CITY OF ALBUQUERQUE

**Planning Department
Transportation Development Services**

December 31, 2015

**Re: Santuario de San Martin De Porres
8301 Camino de San Martin SW
30-Day Temporary Certificate of Occupancy- Transportation Development
Engineer's/Architect's Stamp dated 12-18-13 (M10-D002)
Certification dated 12-29-15**

REVISION DEC.21.2015 Site AA
• ACCESSIBLE PARKING SPACE LOCATIONS REVISED FROM ORIGINAL LAYOUT. SAME QTY. AS APPROVED BY A.A.
• ACCESSIBLE AISLES WIDENED.

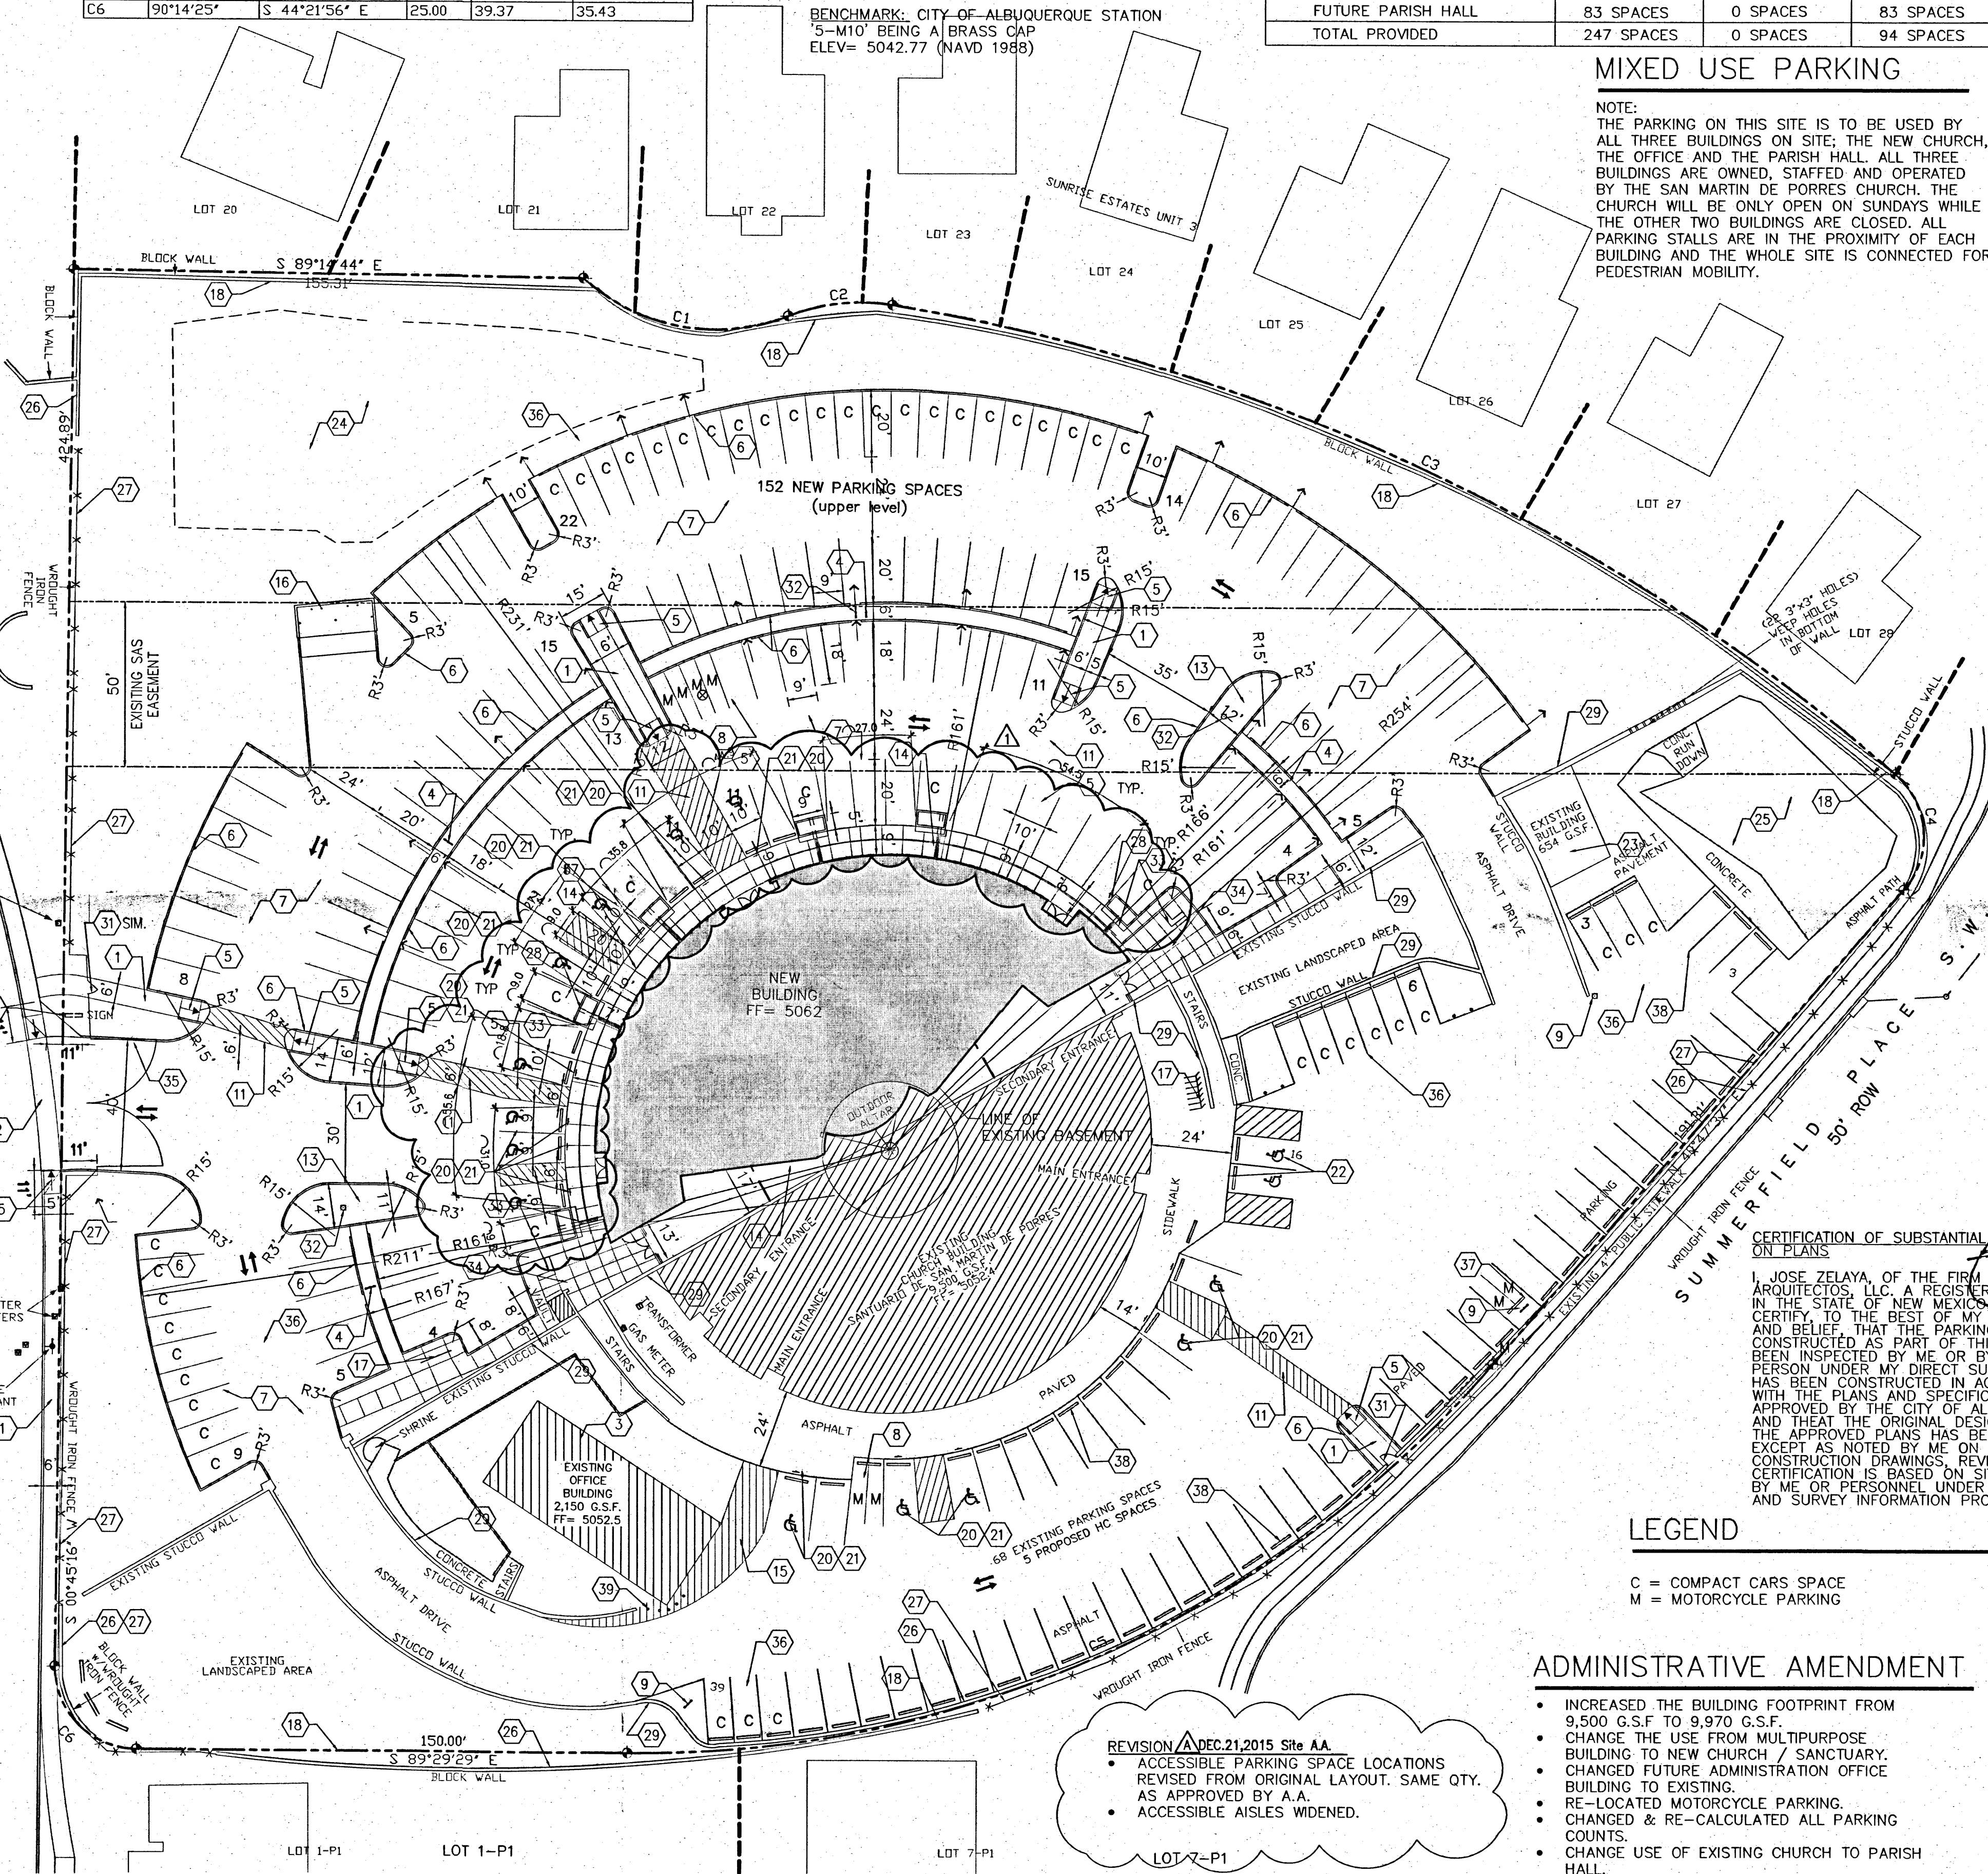
- The ADA accessible parking sign must have the required language per 66-7-352.4C NMSA 1978 **"Violators Are Subject to a Fine and/or Towing."**
